From: Simon Davis
Sent: 23 July 2019 15:26
To: Kathryn Block [REDACTED]
Cc: Zoe Knott [REDACTED]
Subject: RE: Y/98/18/RES and Y/97/18/DOC

Subject: RE: Y/98/18/RES and Y/97/18/DOC

BOVIS HOMES
scheme: Land off Burndell Road Yapton
client: Bovis Homes
drawing: Hard Landscape Proposals
date: Nov. 2018
scale: 1:200@A1
drawing no: BOV22172 12E sheet 4
drawn: AE checked: DKM

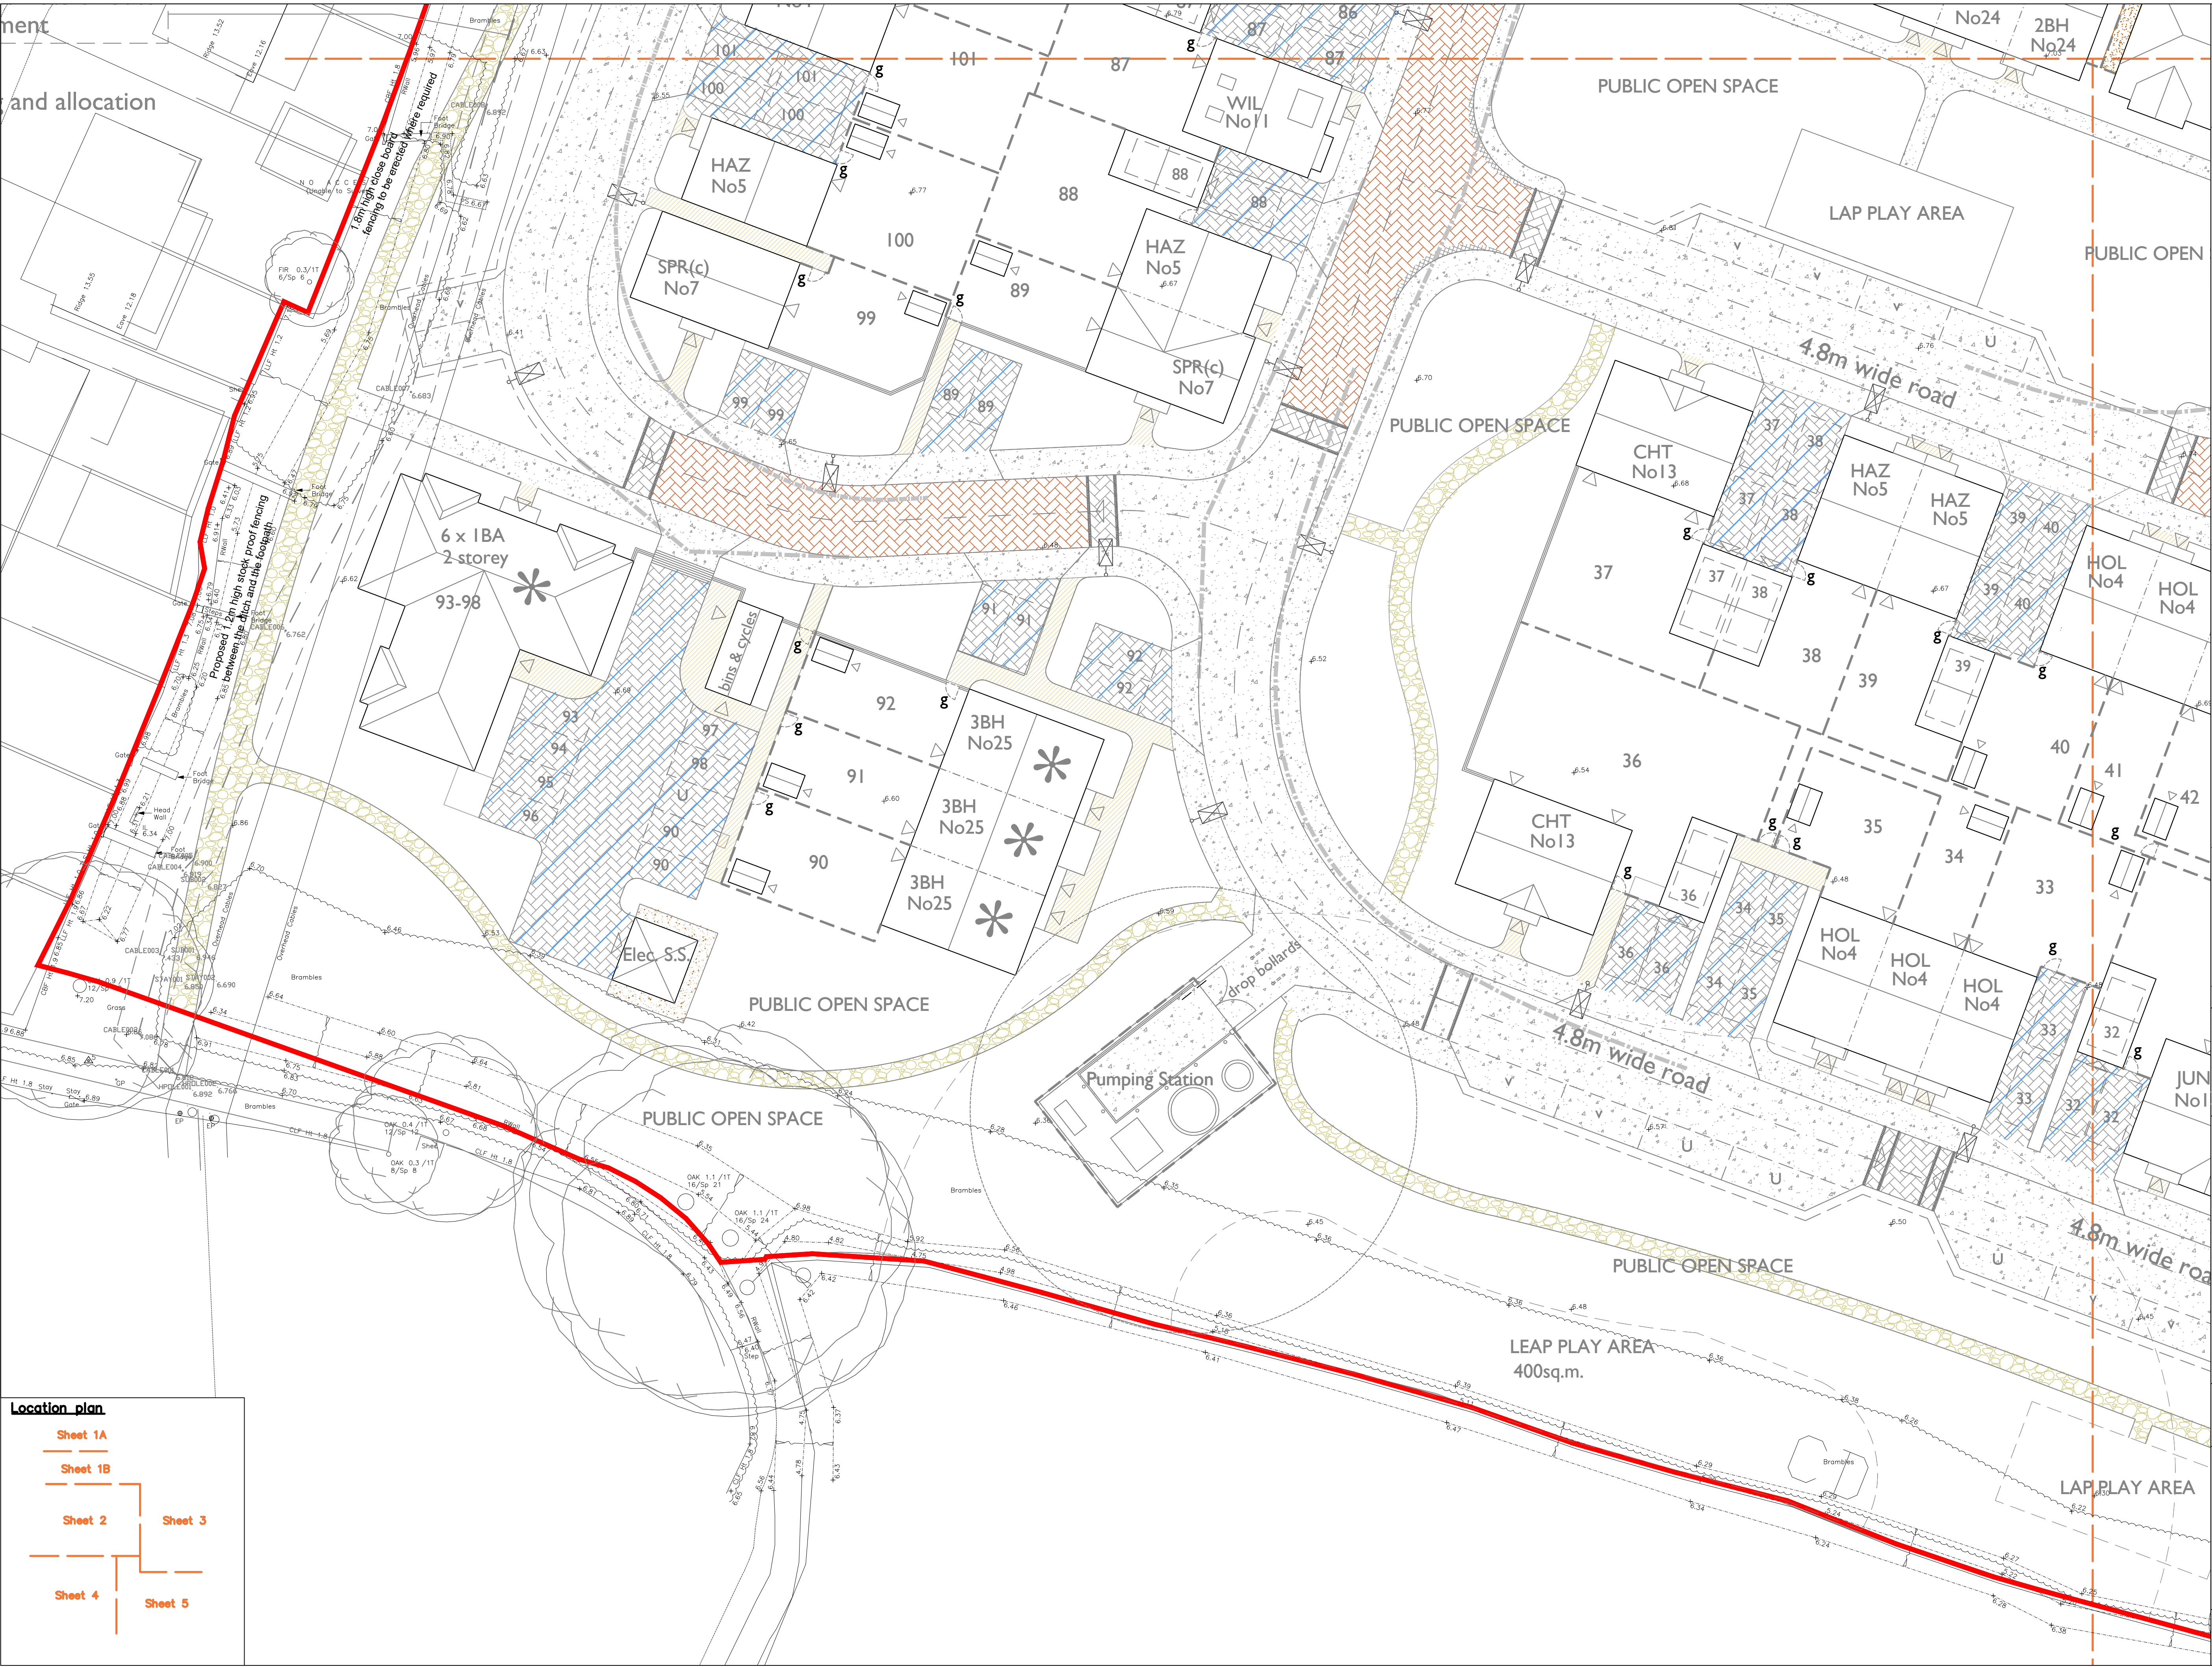
2. Sheet 4 of the latest Landscape Plan (BOV22172-11 Rev L) is missing the SW corner of the scheme
3. I appreciate its late in the process but looking back at the YPC response, I see they are very keen on the enhancement of the footpath to achieve multi user pathway status. I need to respond to this in the report. Would it be possible at this time to show the widening of the footpath down the western side of the site to achieve this? There is policy support in the ALP (policies T SP1, T DM1) for footpath/public route improvements. Alternatively, would your client be prepared to provide this post permission by way of a pre-occupation/post granting of permission condition? If the answer is no, please explain why for the report.

Please find attached the amended landscape drawing (BOV22172-1.1L-sheet 4) which includes the SW corner of the scheme.

drawing no: BOV22172 11L sheet 5

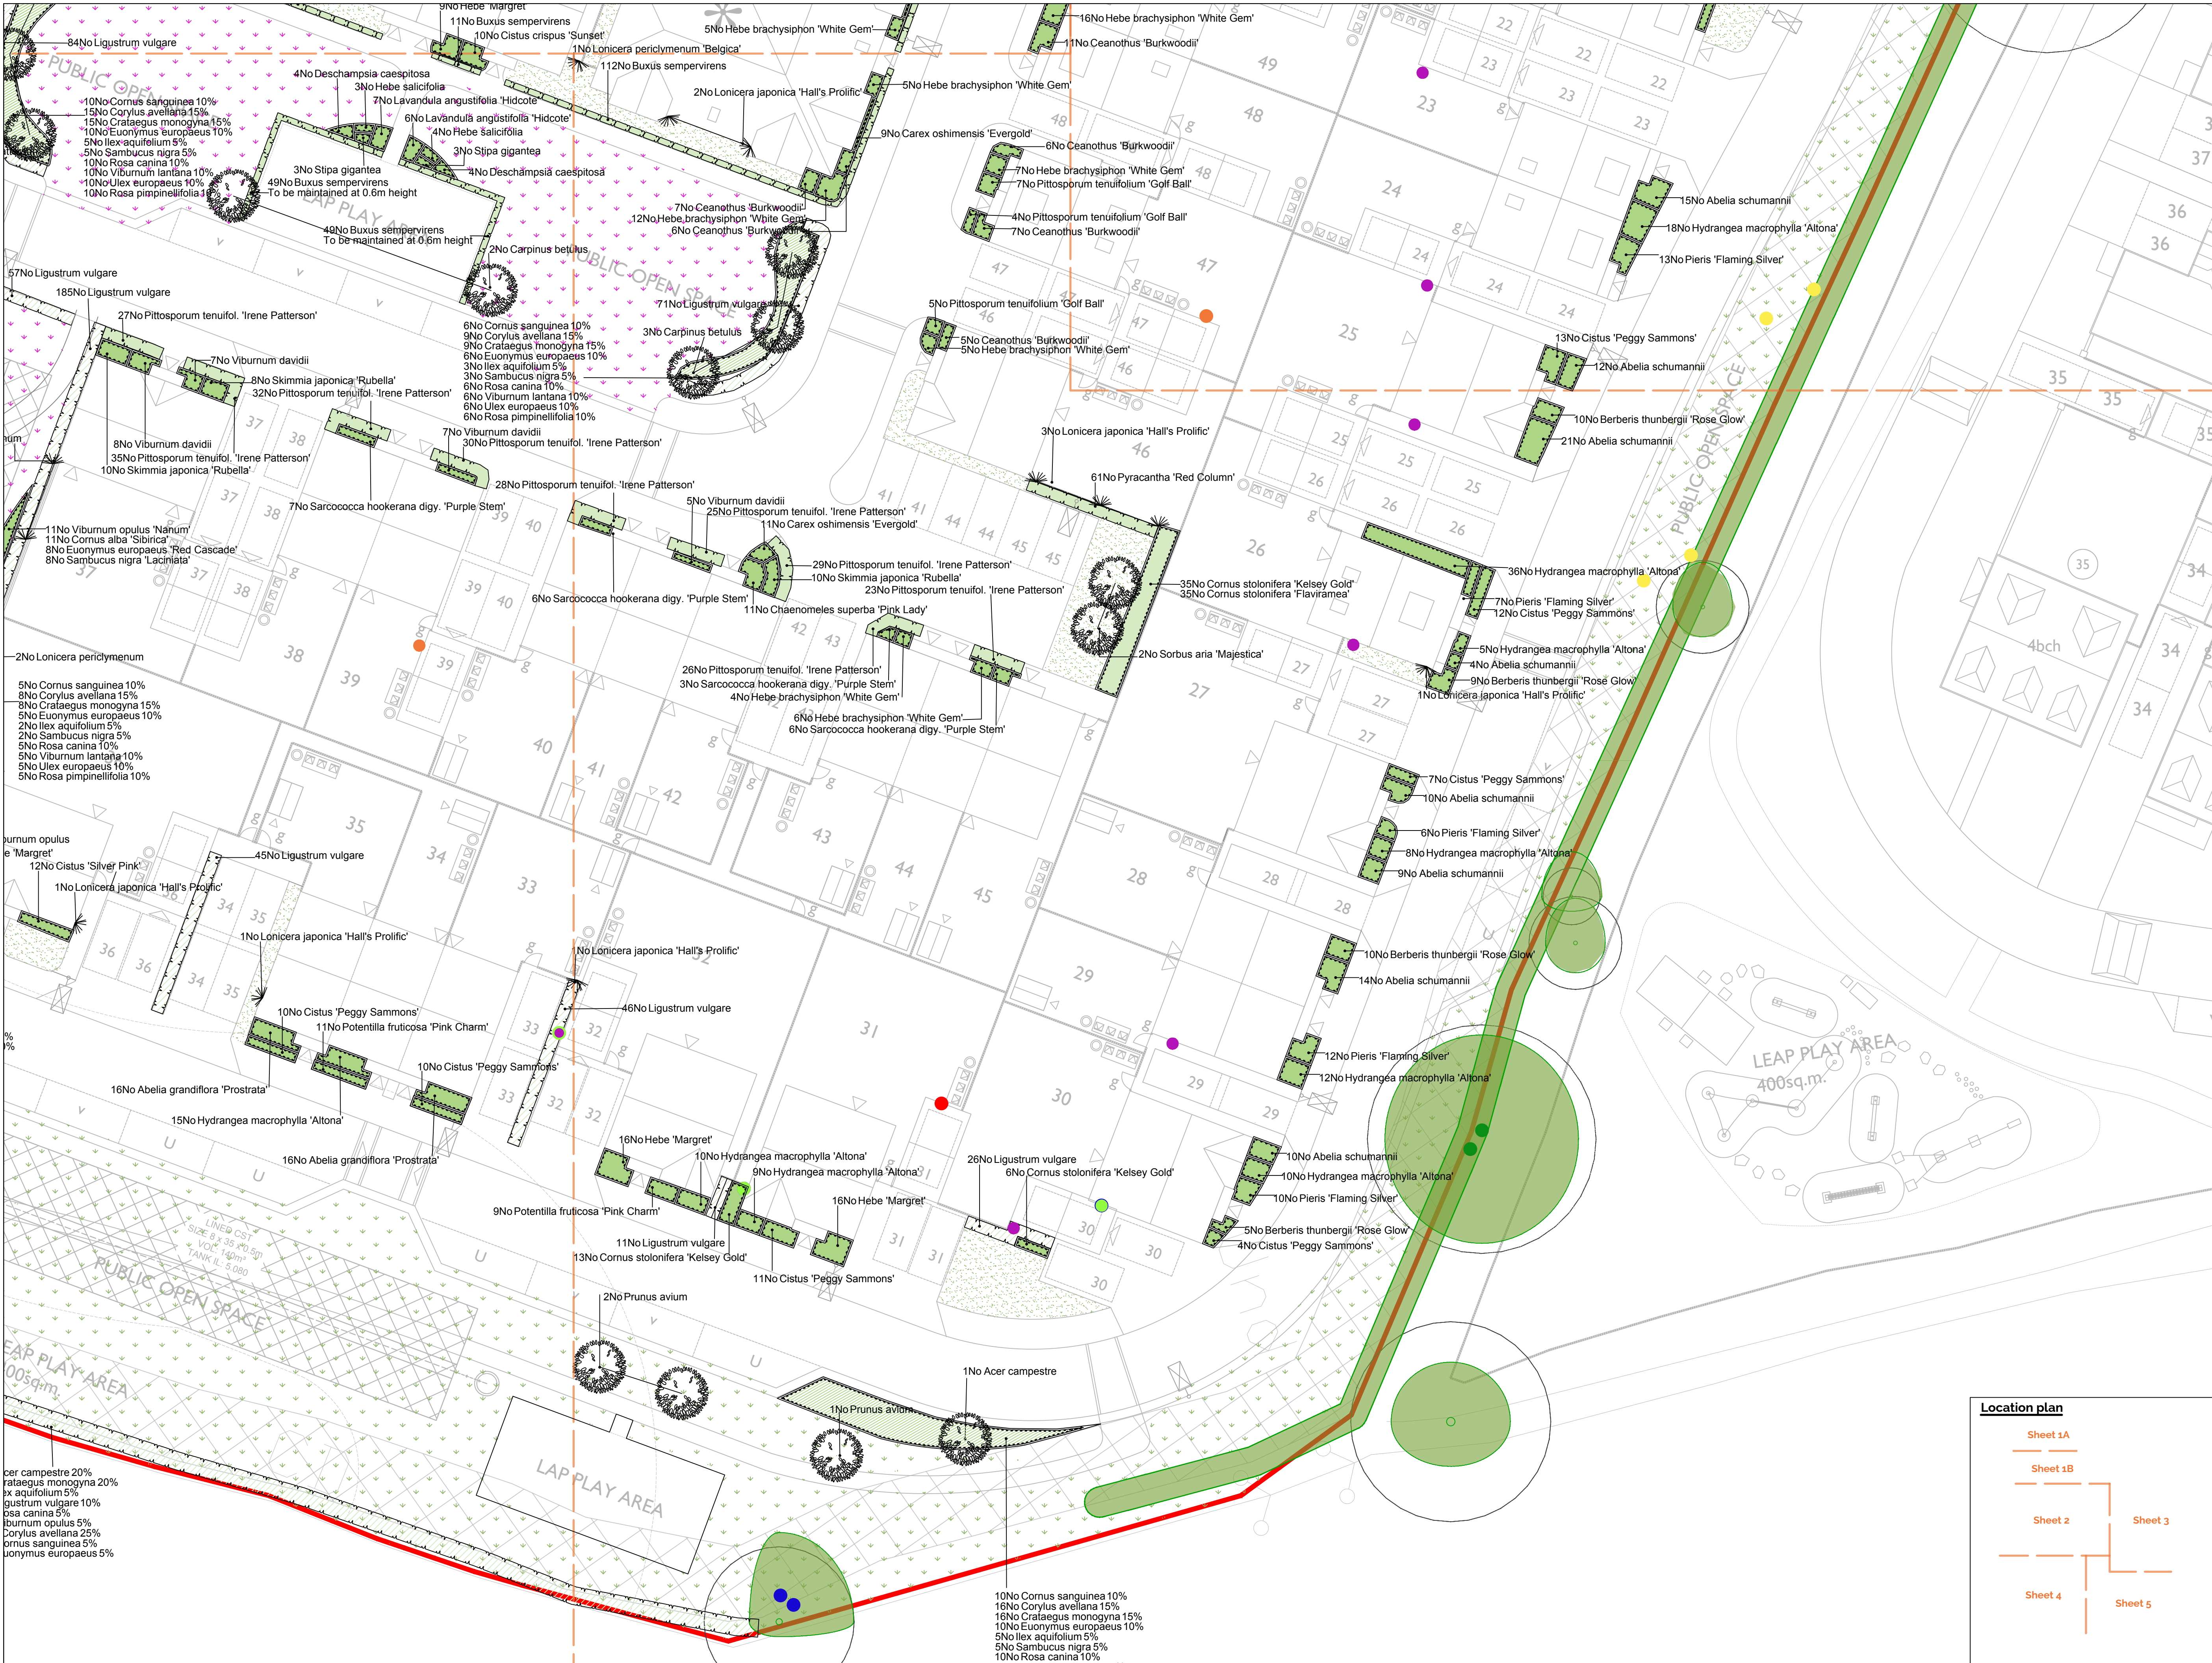
Thank you for the plan. We need certainty that a gap will be left in the SE gap therefore could you further amend the Landscape Drawing Sheet 5 with a note to say that a gap will be left to allow informal pedestrian allow access through into the adjacent site.

1. Can you confirm as per Zoe's email of 20/02/19 that there is a gap in your boundary in the SE corner to allow access through into the adjacent site. I can't see this on the landscape plans or if it is there, it is not clear.

We agreed in our email correspondence (20/02) that there would be a gap in the boundary in the SE corner.
